From: STEPHEN LOCKLESS [REDACTED]
Sent: 16 July 2022 14:04
To: Planning <Planning@arun.gov.uk>
Subject: Objection Planning Application FP/274/21/OUT

We strongly **Object** to planning application FP/274/21/OUT.

Figure 5 – Site A Flood Impact Map Extract

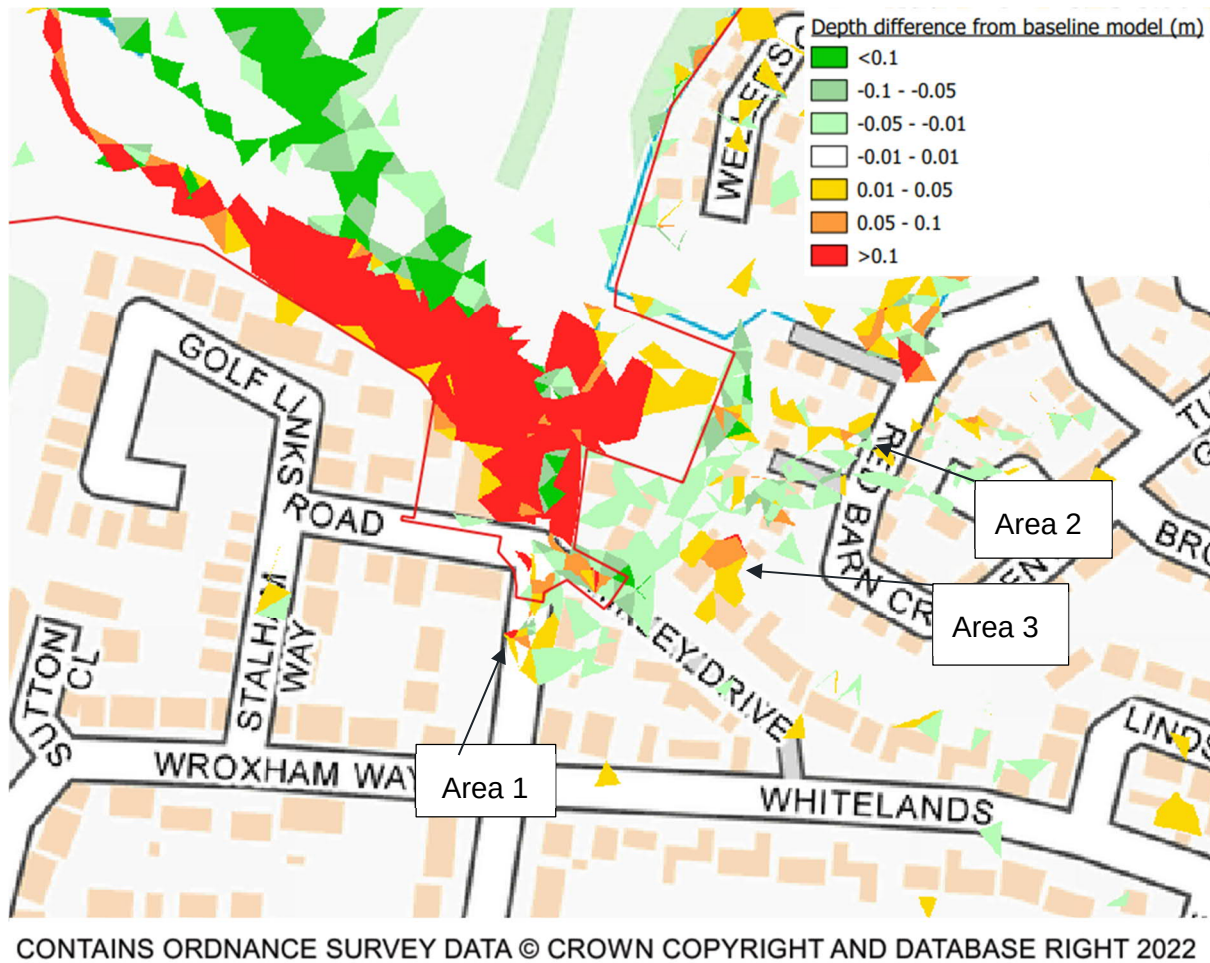
The hydraulic report flood risk conducted shows the areas in which flooding is most likely. To the south of the site along the Golf Links Road area is clearly show in Red (figs 5 & 6 in the Bognor Modelling Report), highlighting this area is most prone to flooding. although the risk has been indicated as not causing a significant detriment to these properties, the detriment is still increased. Current climate change predictions are not realistically expected to decrease in the foreseeable future only to increase therefore any rise in flood risk must be taken extremely seriously to existing properties.
